Subject: RE: Planning Consultation on: CM/69/21/PL

Engineers Comments Regarding Surface Water Drainage

Application No: CM/69/21/PL
Registered: 18th November 2021
Site Address: Land at Northwood Farm Yapton Road BN18 0HR
Grid Reference: 498475 102444
Description of Works: Flexible Generator Plant and associated infrastructure. This application is in CIL Zone 3 (zero rated) as other development and is a Departure from the Development Plan.

Drawing Title:
PROPOSED SITE PLAN

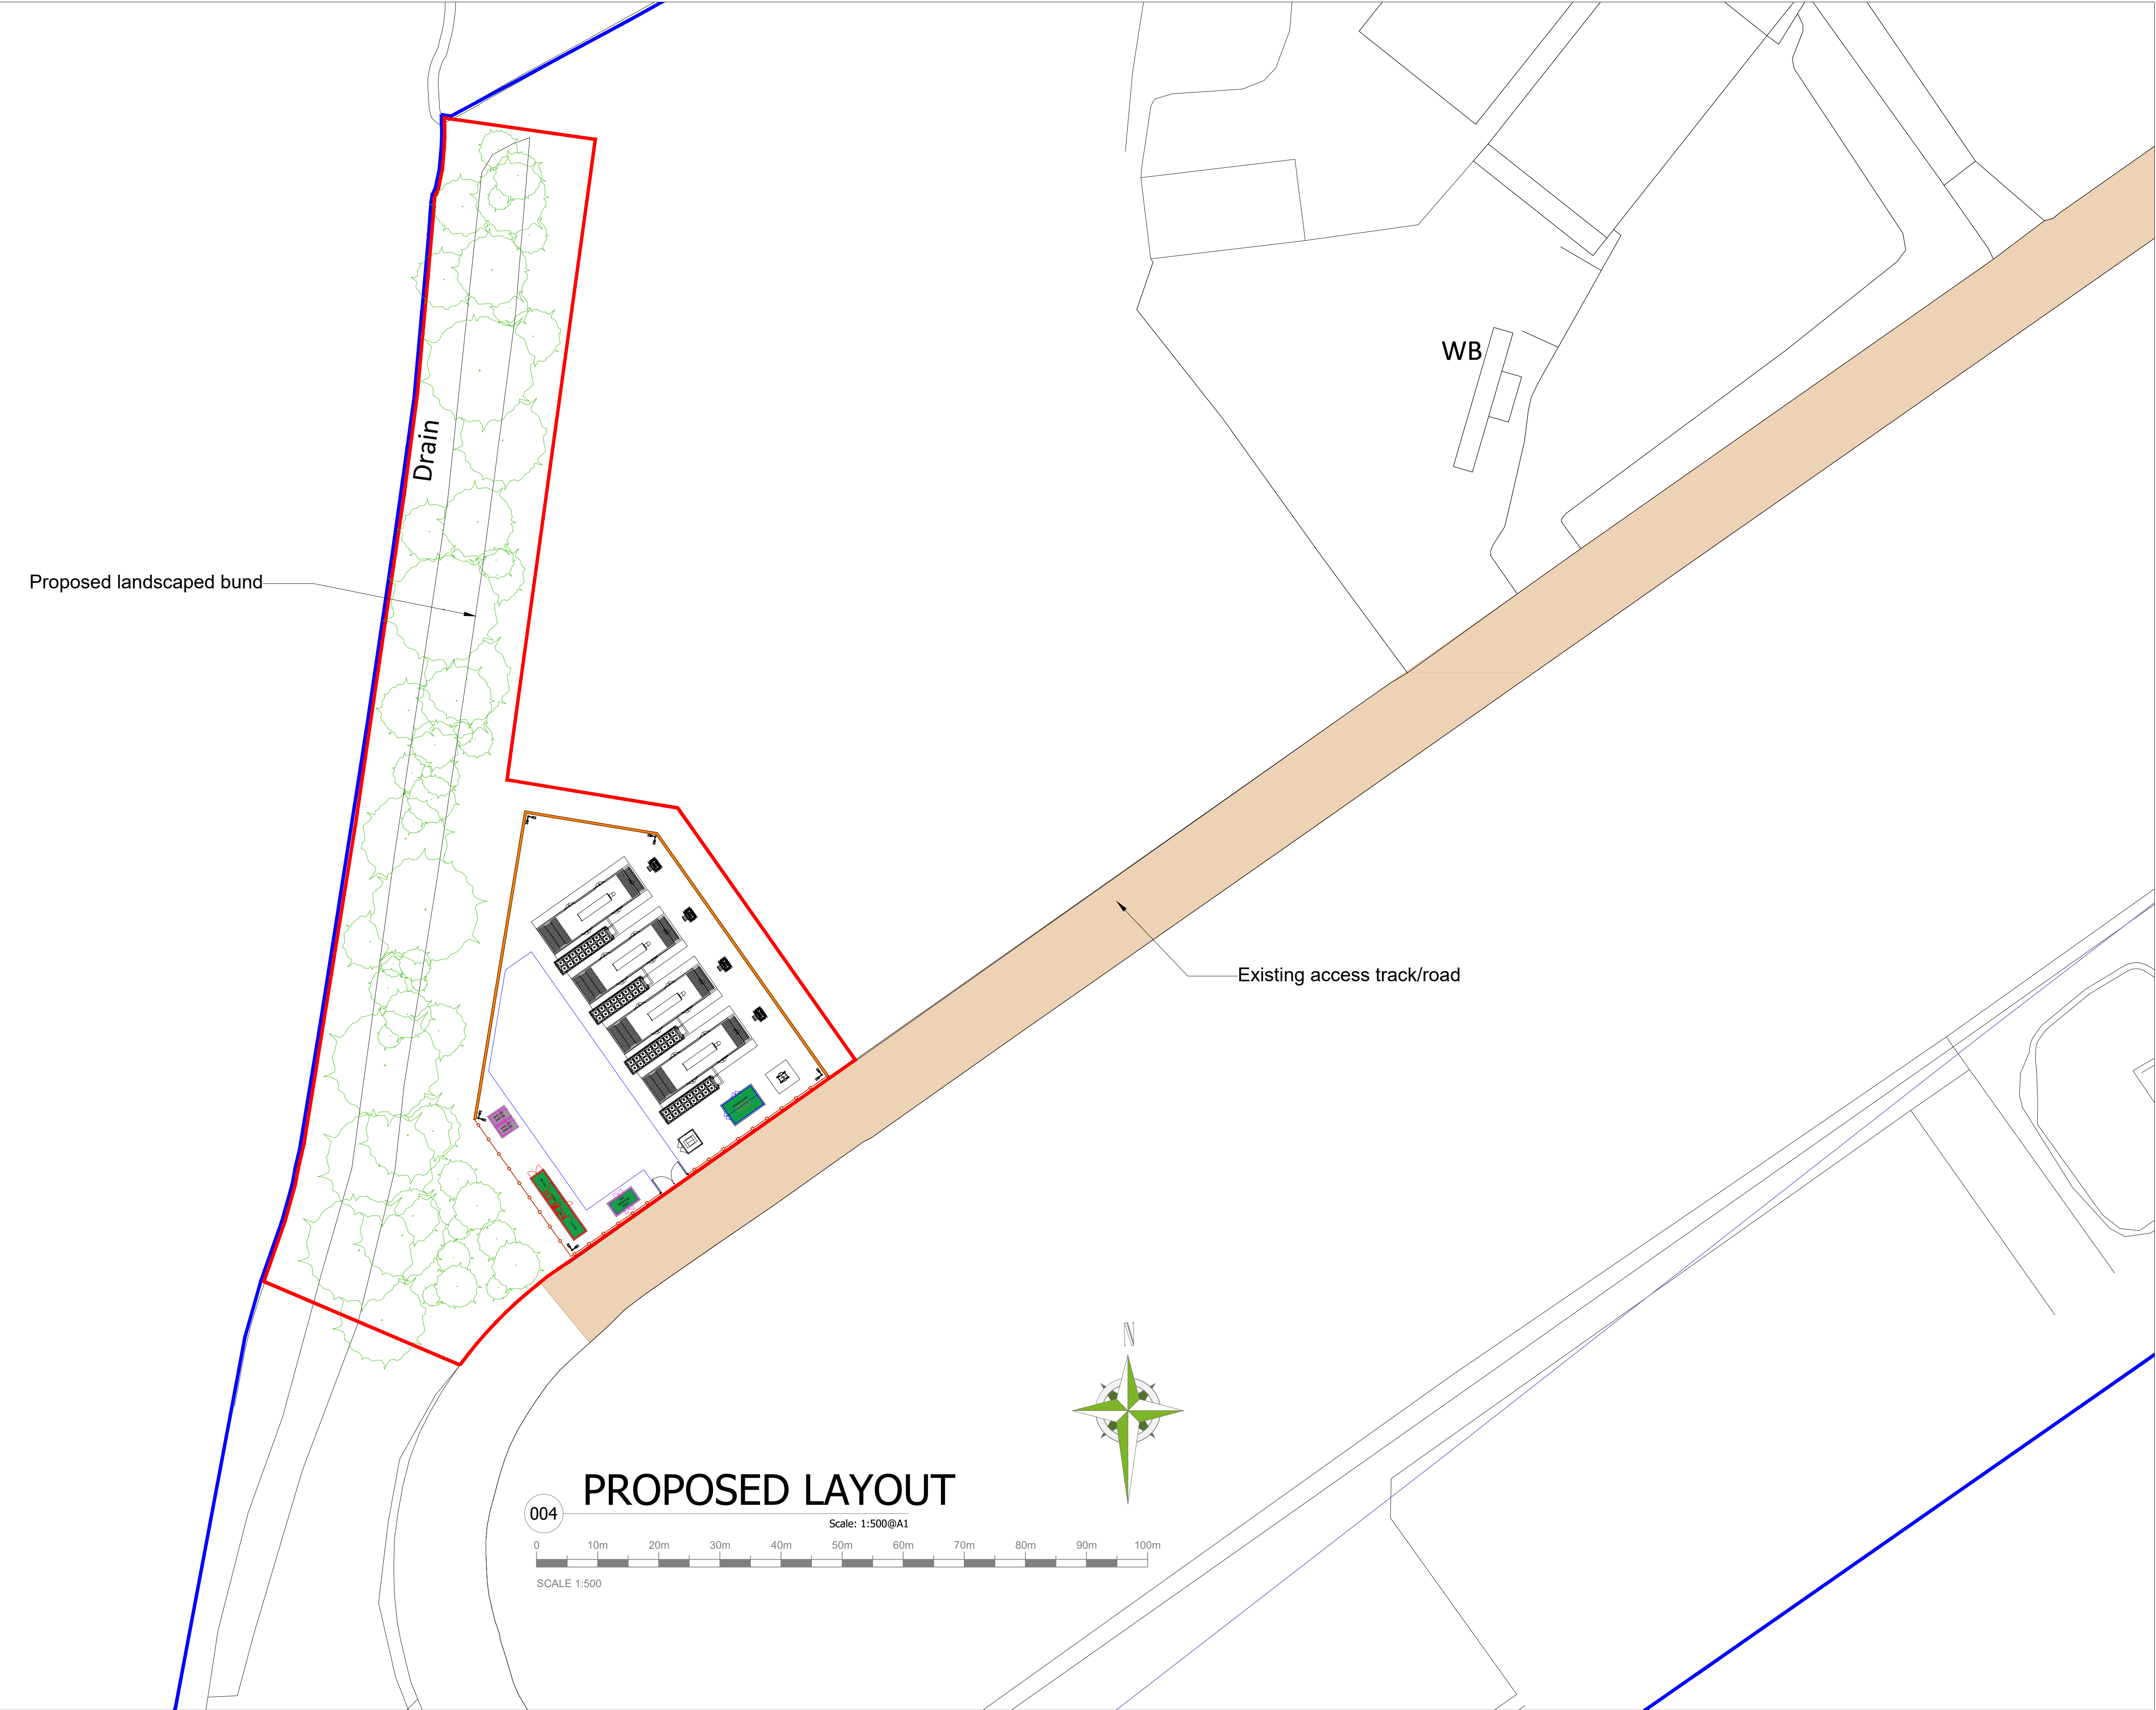
There is a watercourse on the western boundary of the site. If infiltration is not possible as a means of surface water disposal then the applicant will need to investigate discharging flows to this watercourse. Should this be necessary then the applicant will need to apply for ordinary watercourse land drainage consent from WSCC.

Existing and proposed trees (root protection zones) must not conflict with suds features/pipework or the existing watercourse. A 3m easement should be provided from the top of the bank for ease of maintenance.

The development layout must take account of any existing watercourses (open or culverted) to ensure that future access for maintenance is not restricted. No development is permitted within 3m of the bank of an ordinary watercourse, or 3m of a culverted ordinary watercourse."
